A19 Downhill Lane Junction Improvement Scheme

Reference: TR0100024

Issue Specific Hearing (ISH2) held on 16th October 2019: STC Response to Examiner's Questions

Drawing title: **ENGINEERING DRAWINGS
HIGHWAYS GENERAL ARRANGEMENT
REGULATION 5(2)(o)
SHEET 1 OF 2**

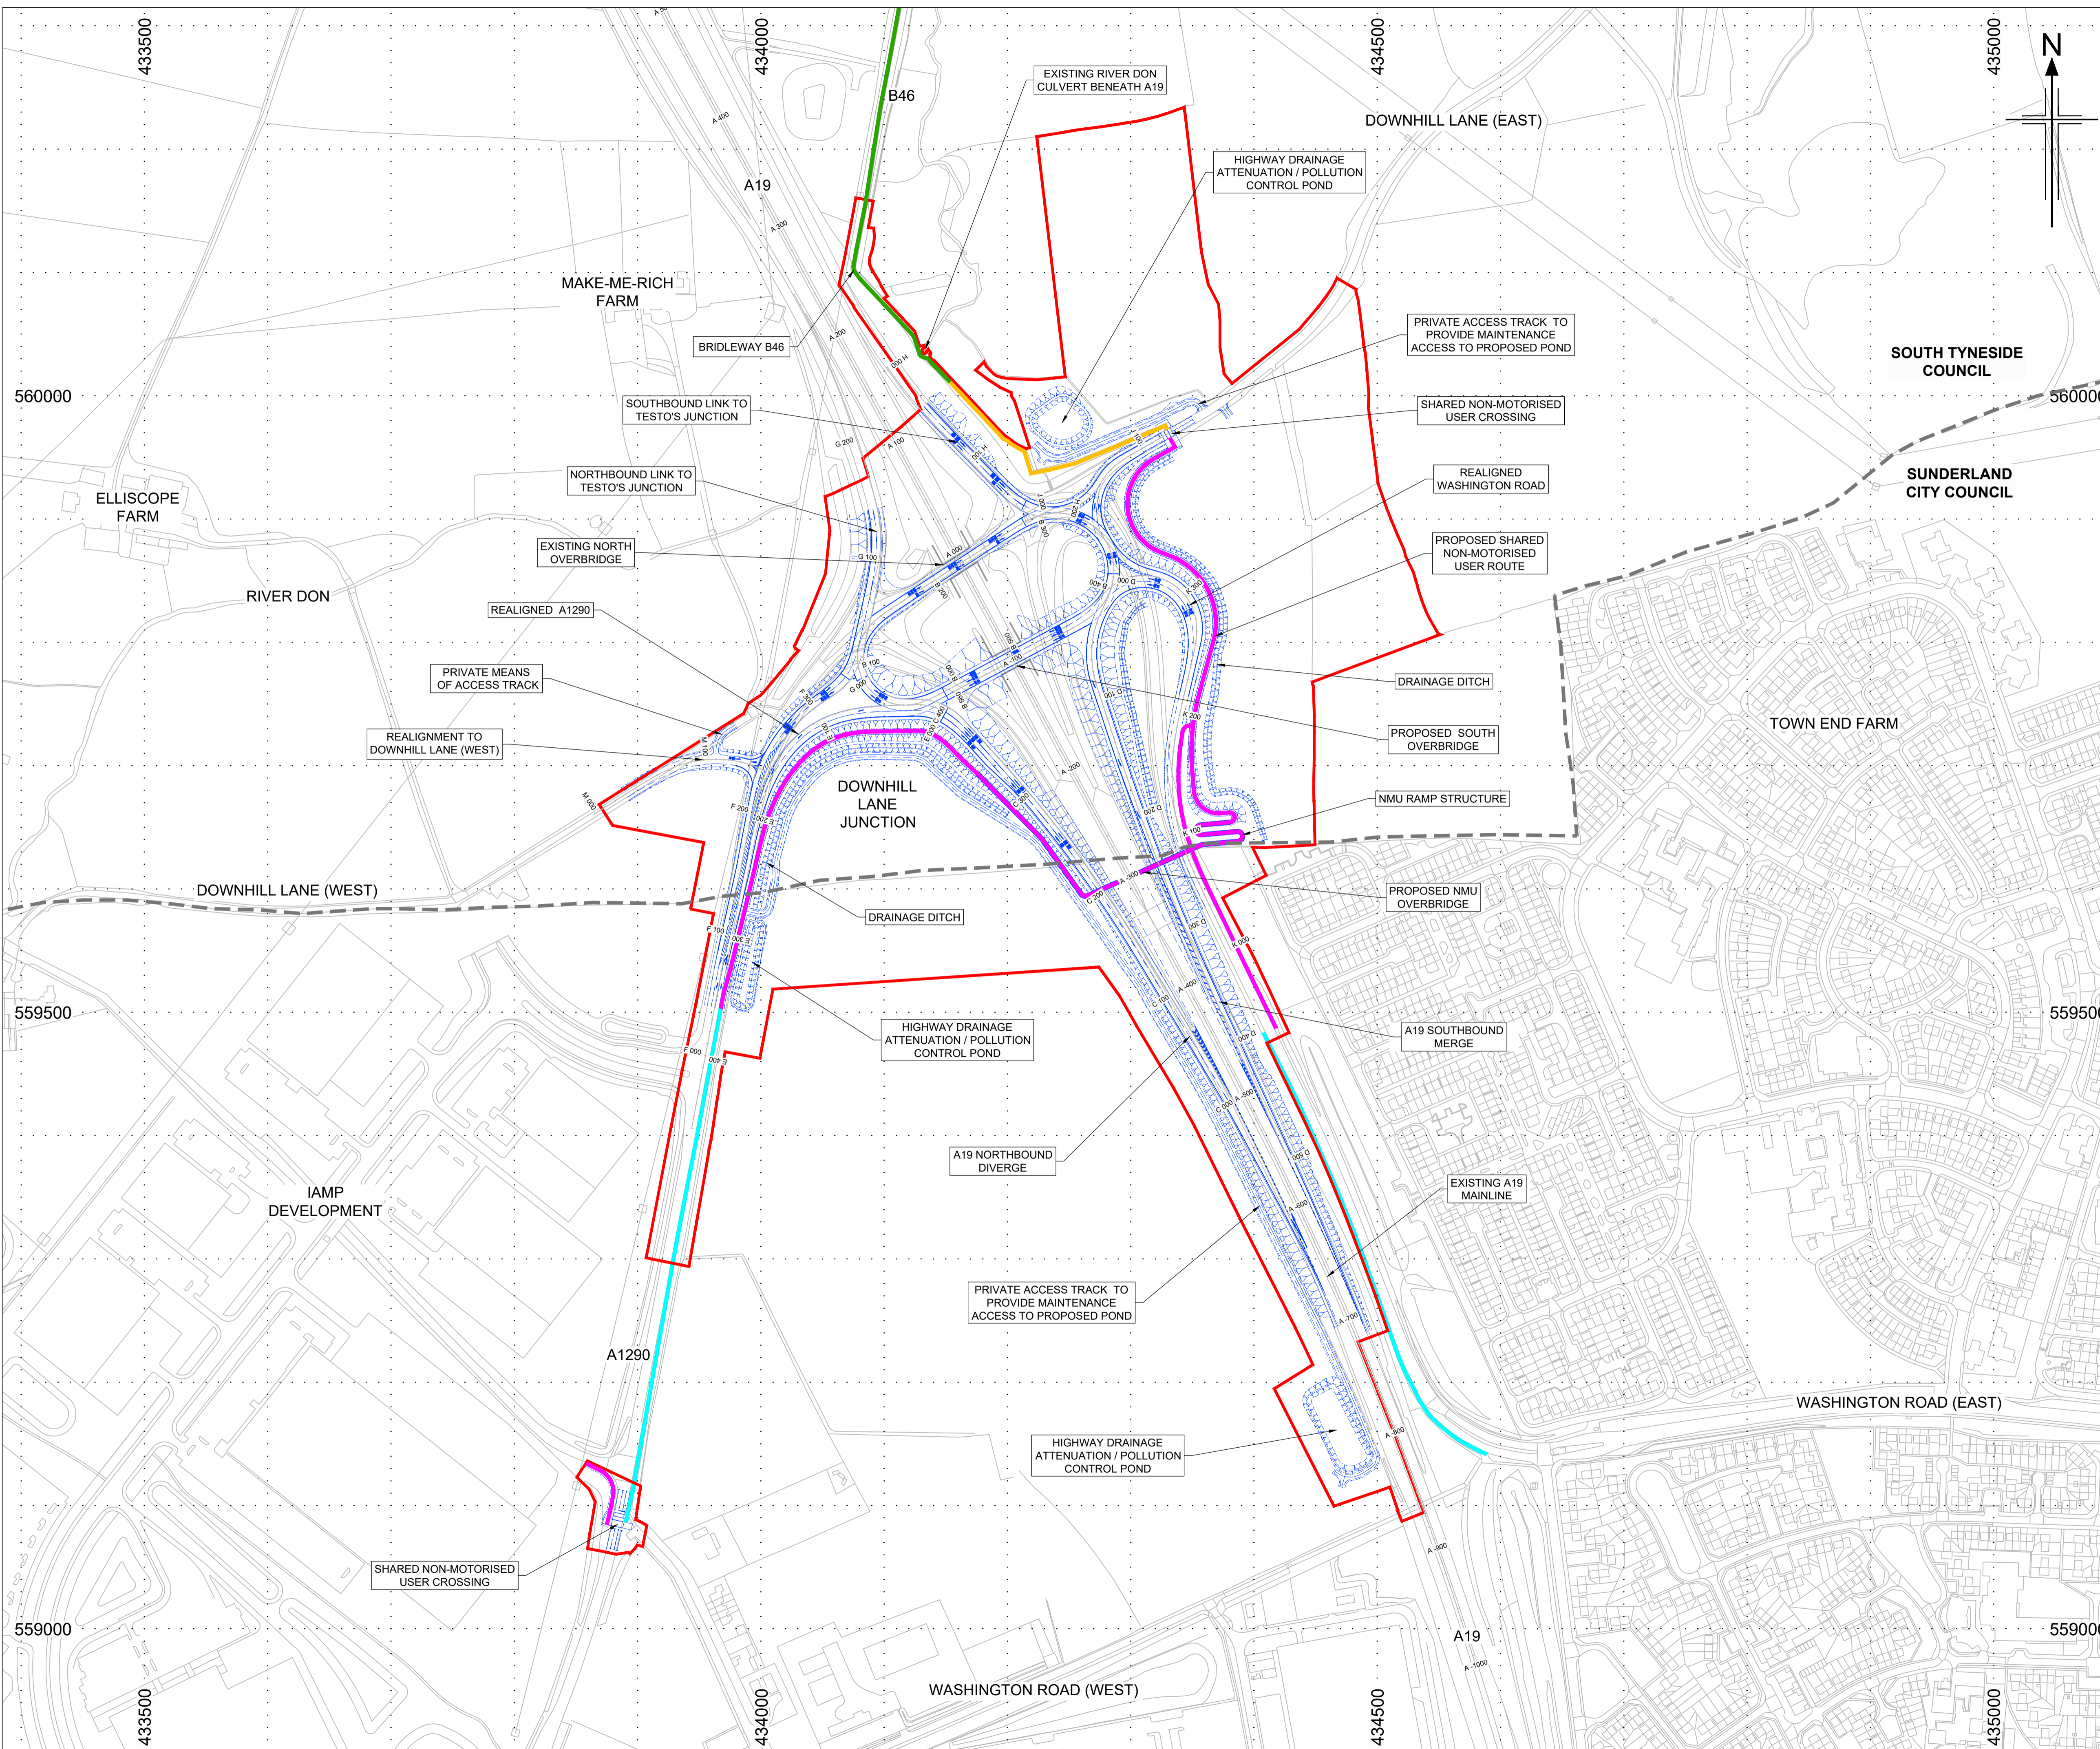
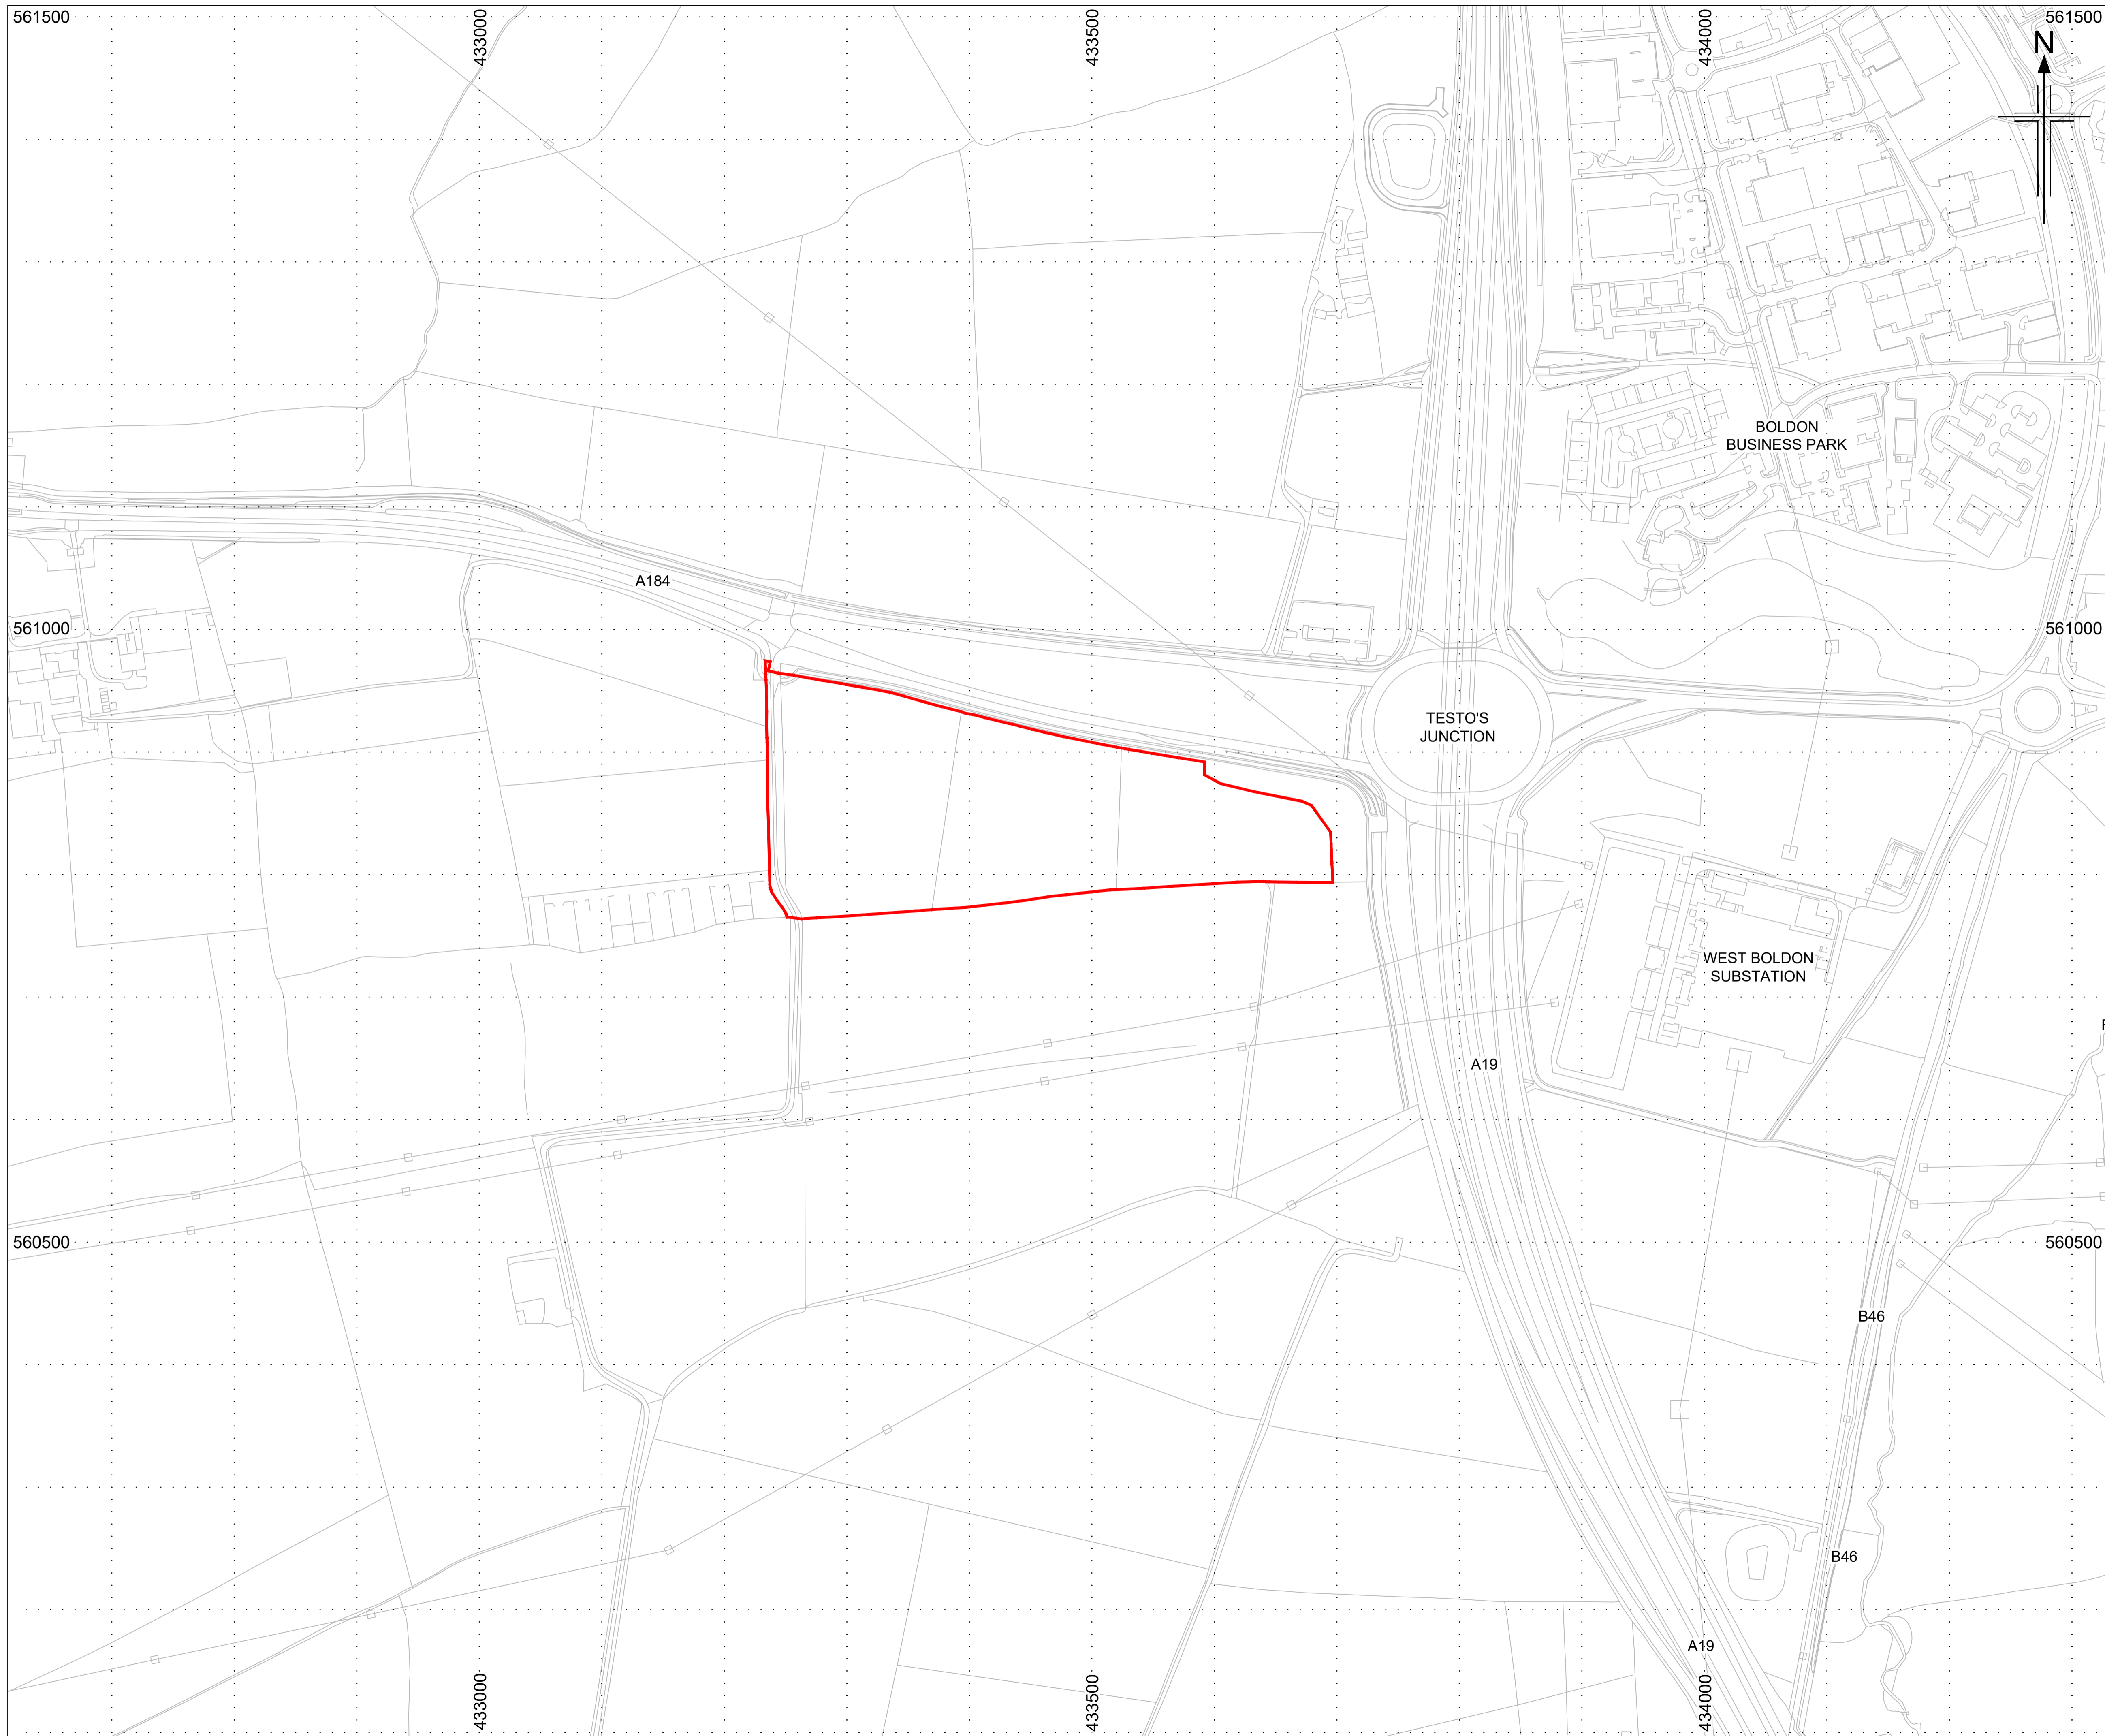
In respect to Q1.9.11 answered by the applicant relating to the provision of a low noise road surface (LNRS). It is noted that this surface treatment will be applied to both the mainline of the A19 and the appropriate slip roads. It is noted that the relevant engineering drawings and sections will be updated with a note setting out the relevant part of the road network subjected to Low Noise Road Survey. Conventional road surfacing materials are considered appropriate for both the circulatory carriageway of the roundabout, approach roads on the local road network connecting with the A19.
